**(Development Charges Letter)**

File No. : **CMDA/PP/NHRB/C/0309/2020**

Sub: CMDA-Area plans Unit - 'B' Channel (Central) – The Planning Permission for the proposed construction of Floor + 5 Floors Residential building with 10 dwelling units at Plot No.C 457, Door No:32, 48TH STREET Nagar housing scheme, Ashok Nagar, Chennai comprised in Old S.No. 148/2 part, TS.No. 58, Block No Kodambakkam village within the limit of Greater Chennai Corporation - Remittance of DC & Other charge advice Sent - Reg

SITE cum STILT FLOOR PLAN

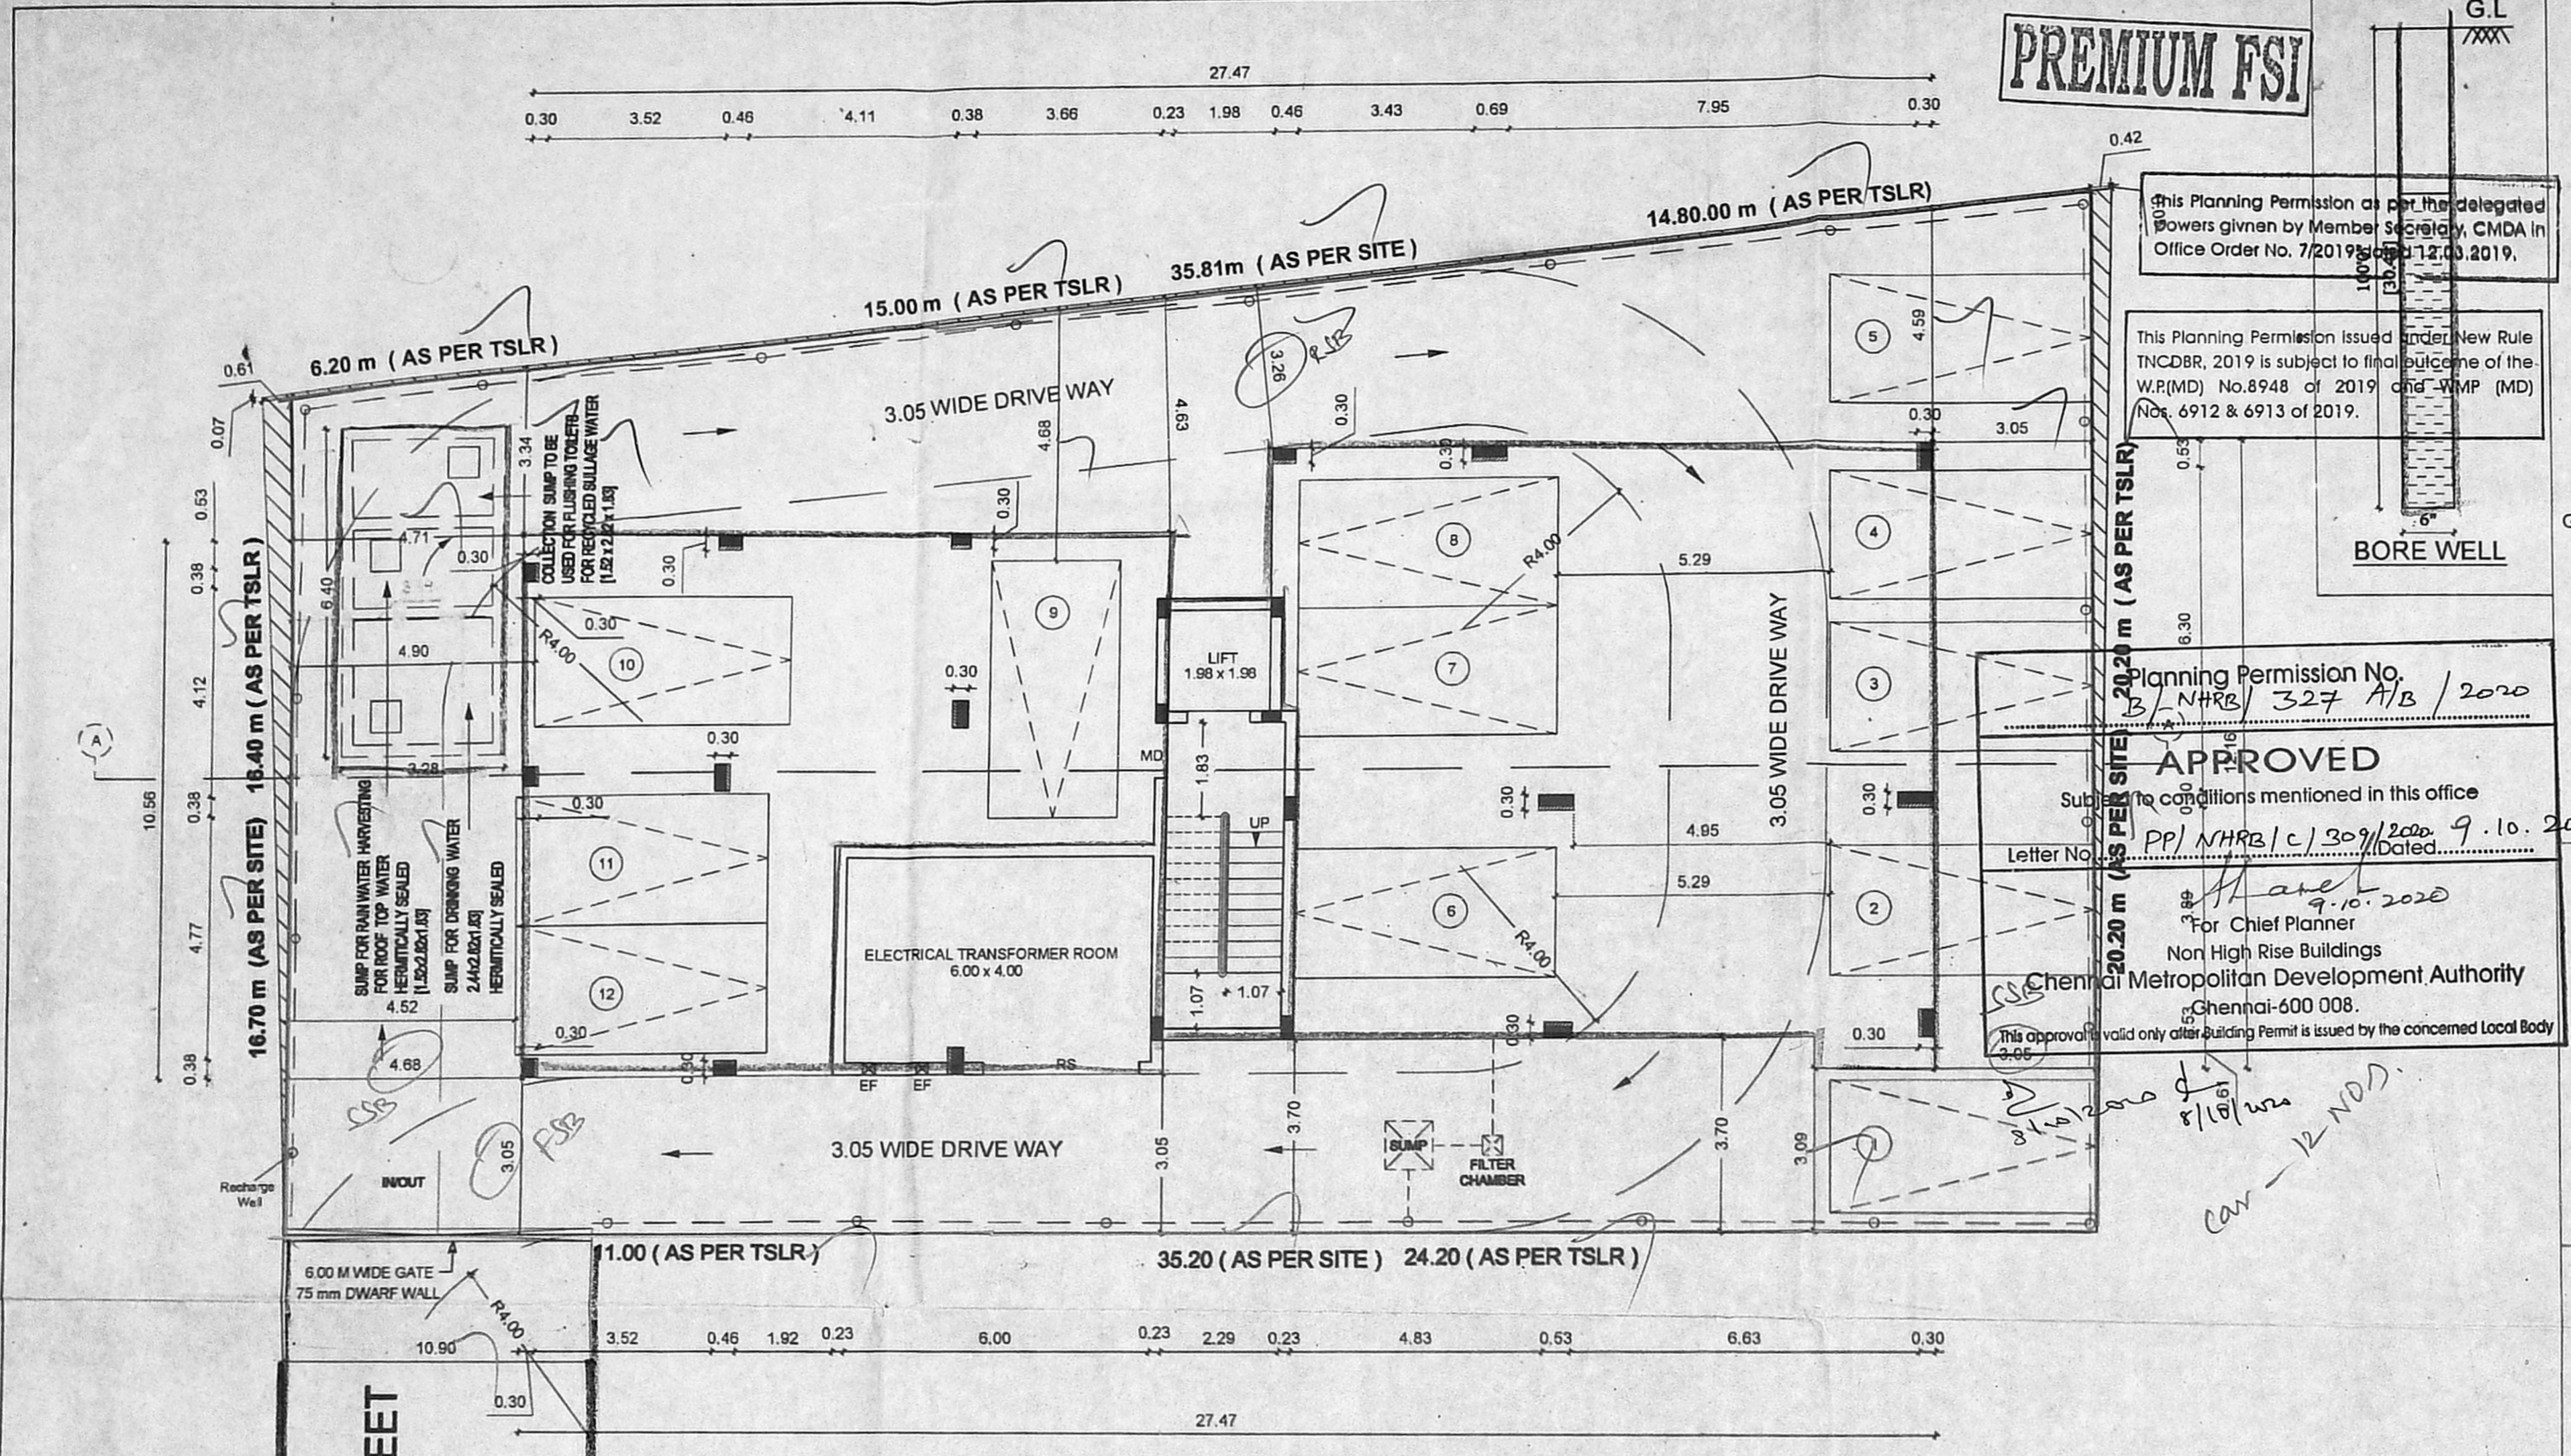
- The dimension of site both as per FMB and as per site condition distinguishing the difference area by hatching ; set back from minimum dimension line to be shown correctly.
- Car parking lot No. 10 to be deleted.
- CMDA Registration copies for Developer, Architect, Structural Engineer, Construction Engineer and Geo-tech to be furnished.
- Survey plan sketch for the site u/r attested by the Revenue officials not below thw rank of Deputy Tahsidar of Concern Taluk to be furnished.
- Notarized copy of approved demolition plan from Greater Chennai Corporation to be furnished.
- Area statement, Title of plan, Road width, Terrace floor plan, Section and Elevation to be shown correctly.
- Solar water heating system shown in the terrace floor plan to be removed.
